East Anglia TWO Offshore Windfarm

Change Request: Amendment to Order Limits at Work No. 9 (Plot 13)

Applicant: East Anglia TWO Limited
Document Reference: ExA.AS-1.D9.5.V1
SPR Reference: EA2-DWF-ENV-REP-IBR-001104

Date: 22nd April 2021
Revision: Version 01
Author: ScottishPower Renewables and Royal HaskoningDHV

200

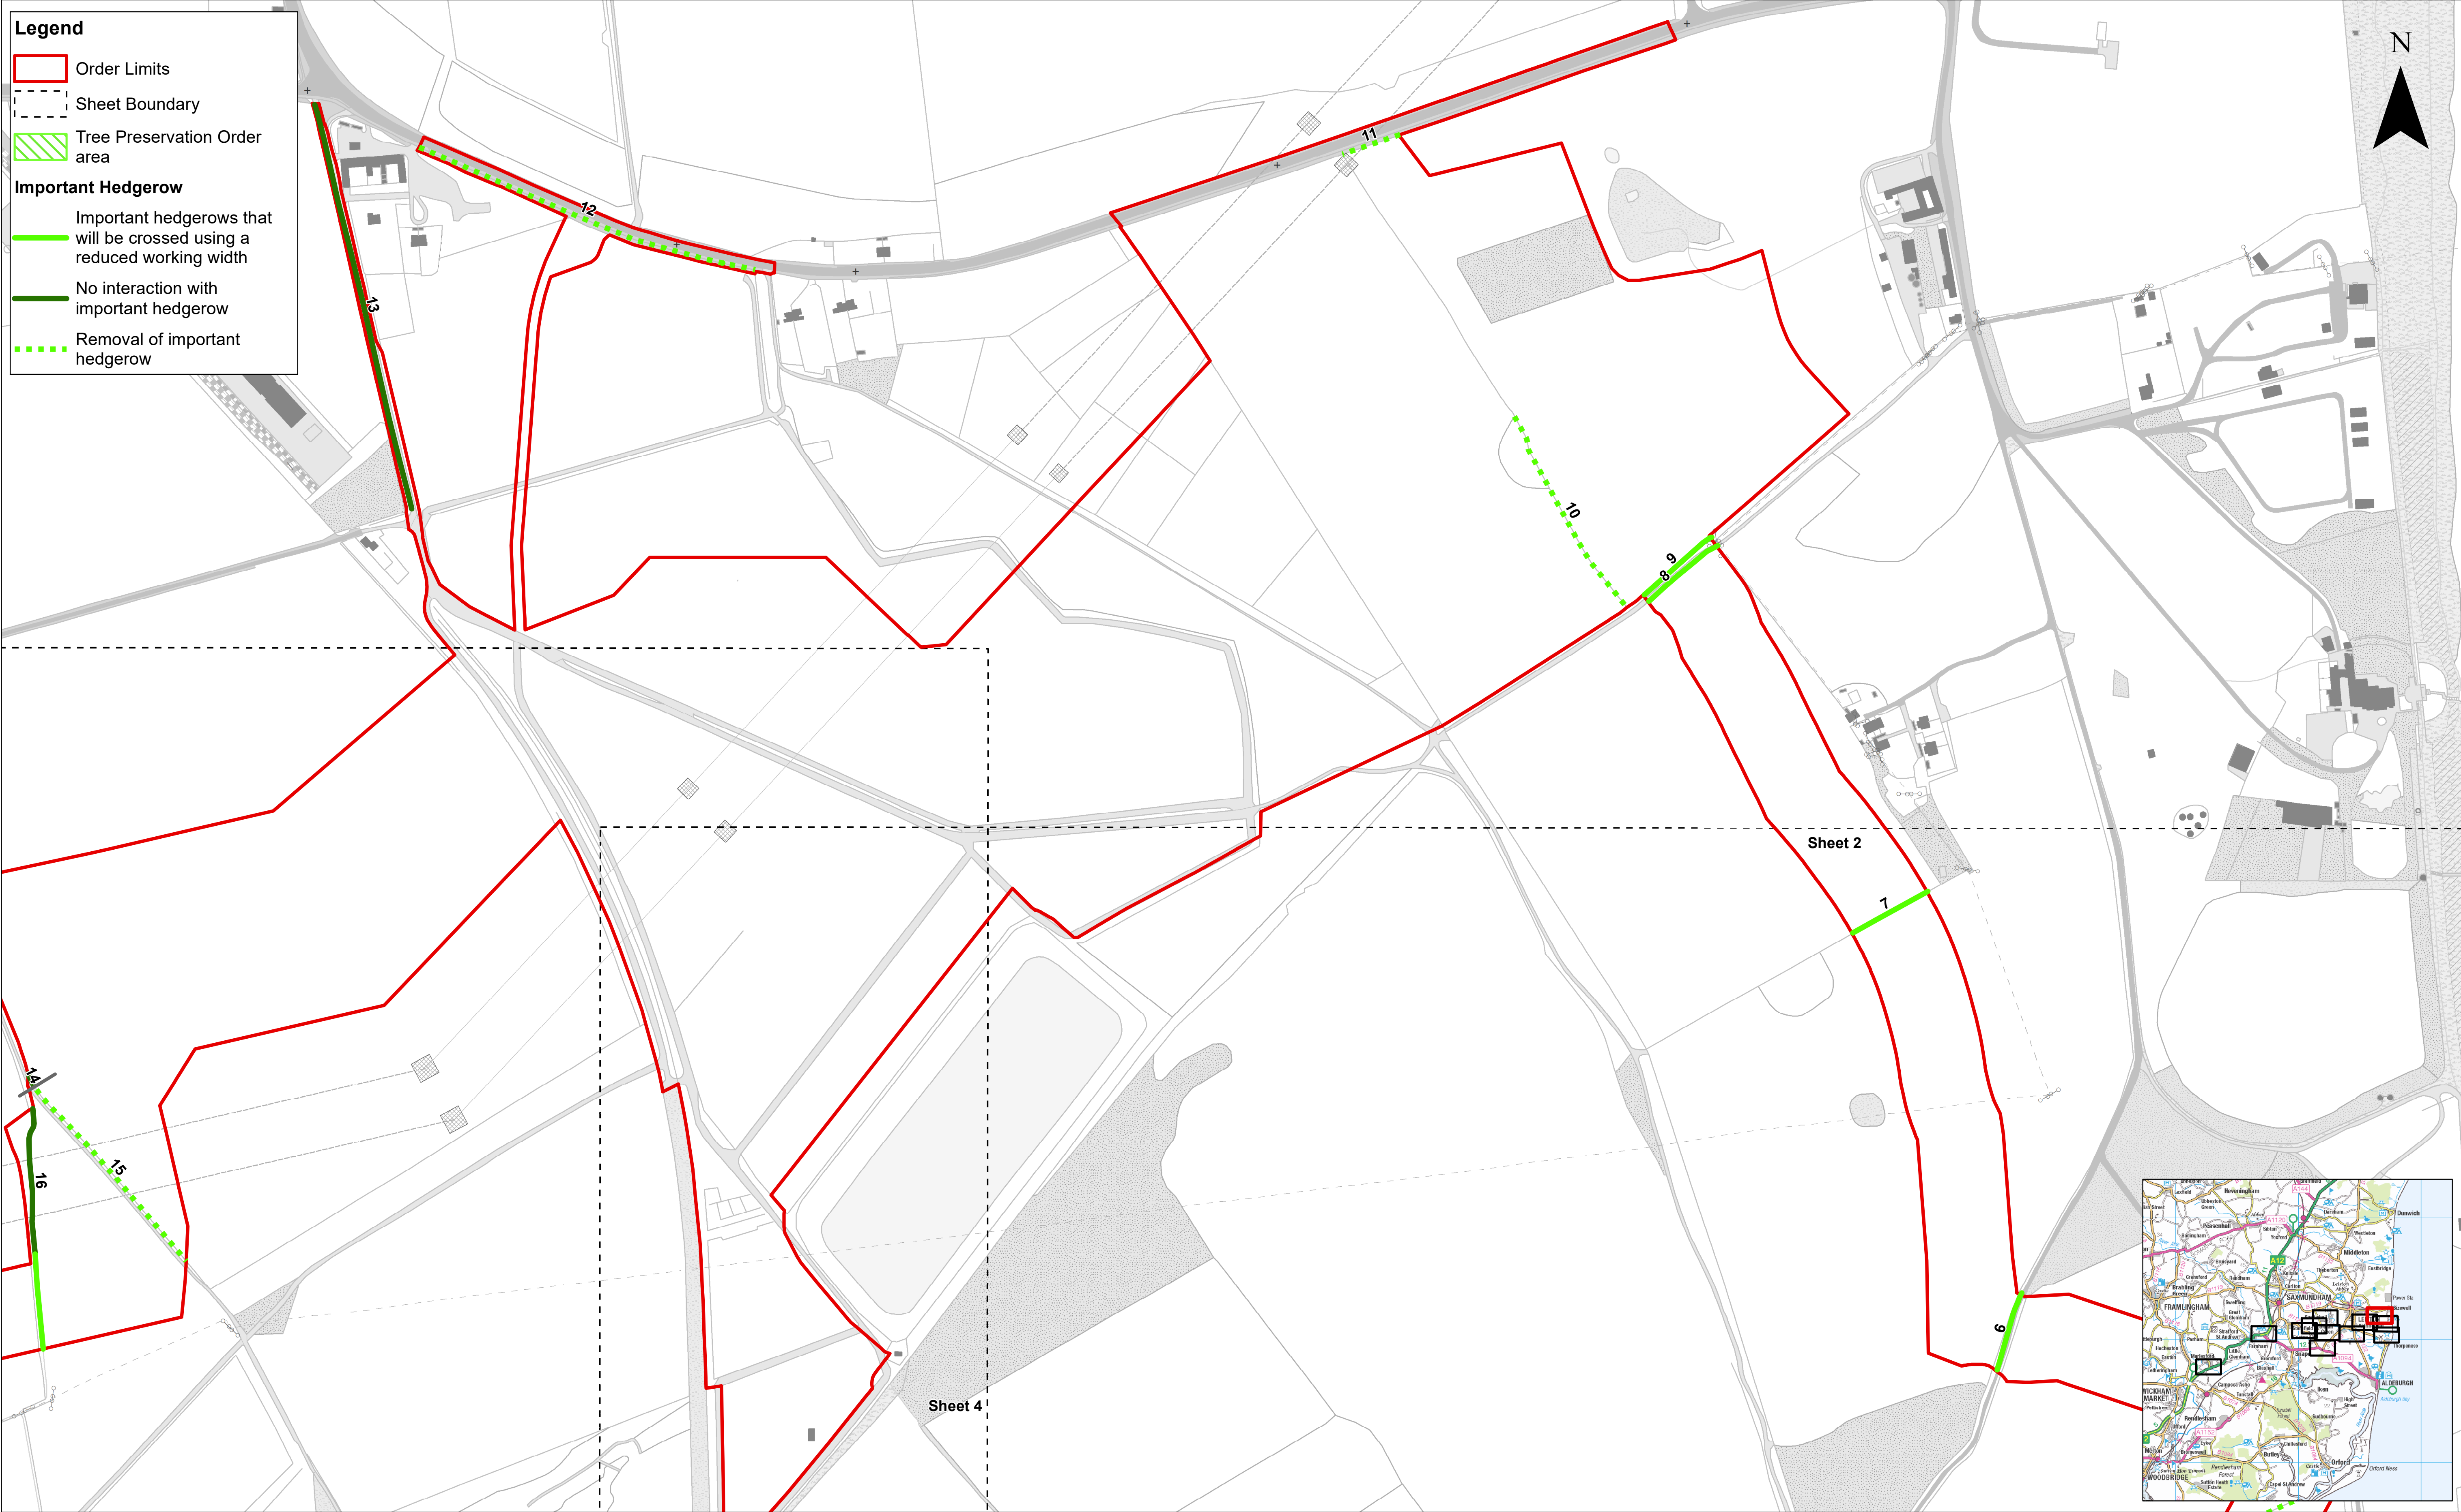
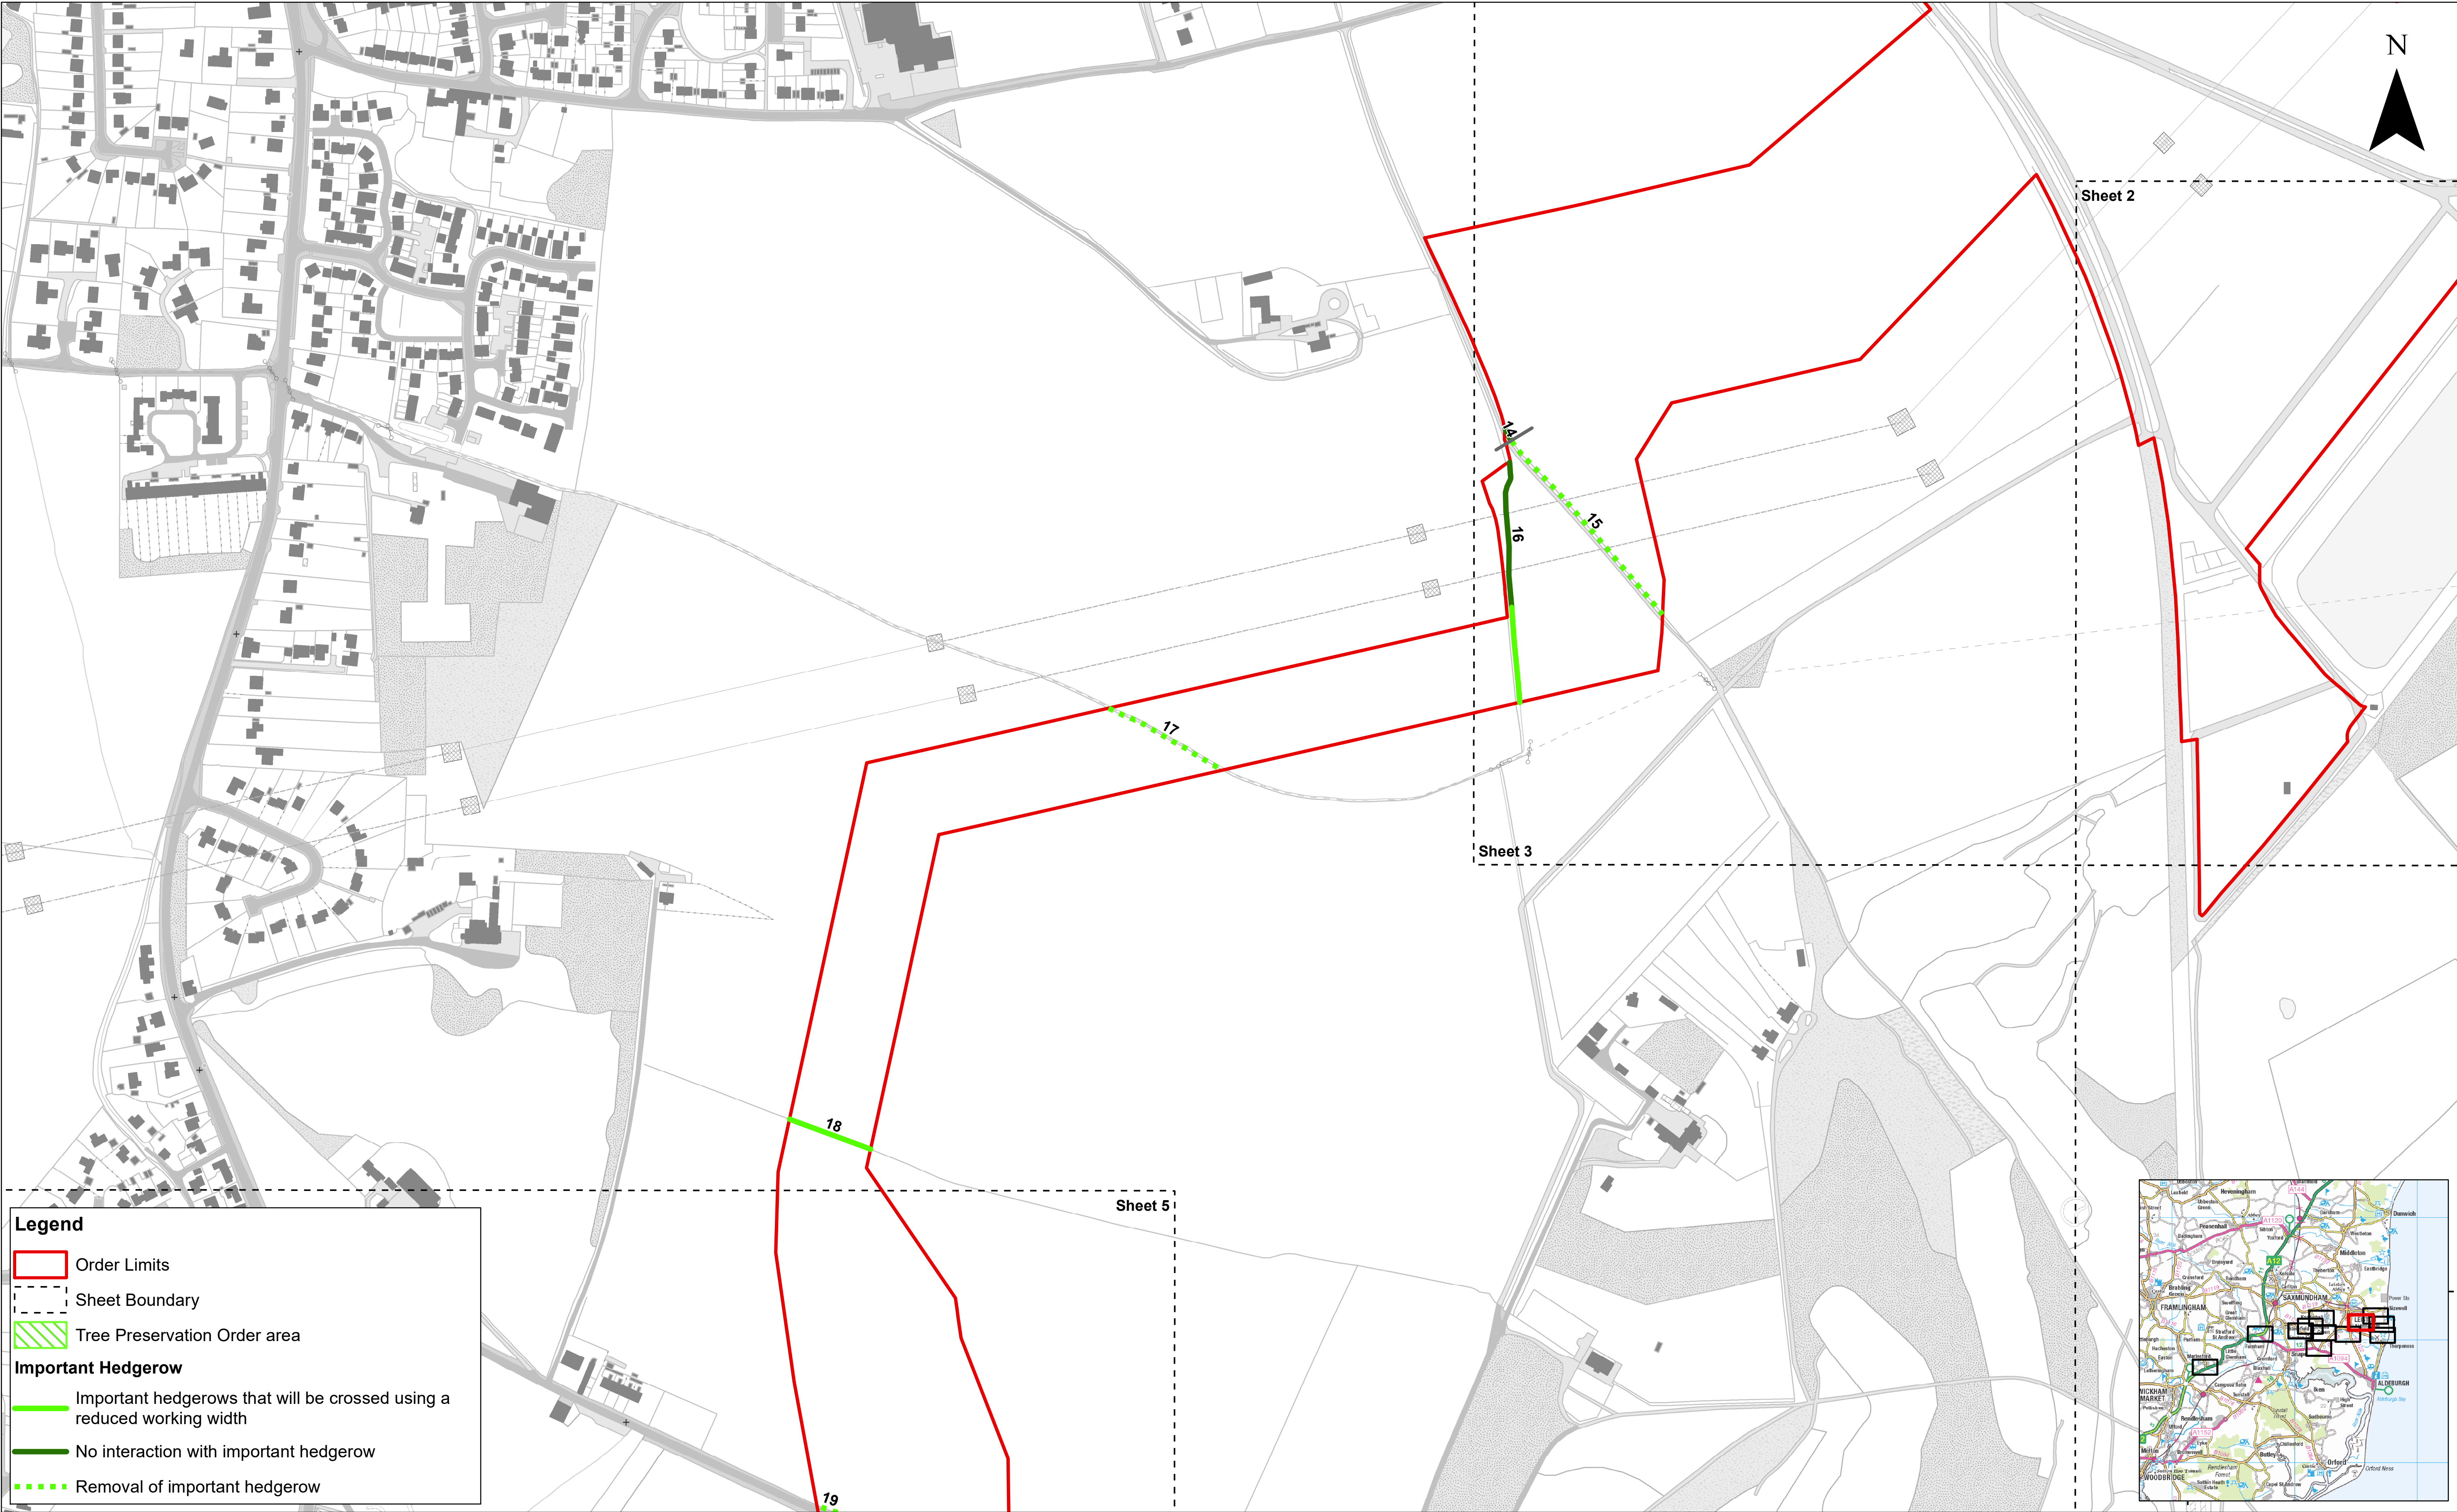
14. Given the revised alignment of the onshore cable corridor at this location, the crossing of important hedgerow 4 (shown on the **Important Hedgerows and Tree Preservation Order Plan** (document reference 2.10)) will be undertaken at a reduced width of 16.1m per project. Additionally, there will no longer be a need to remove any part of important hedgerow 5.
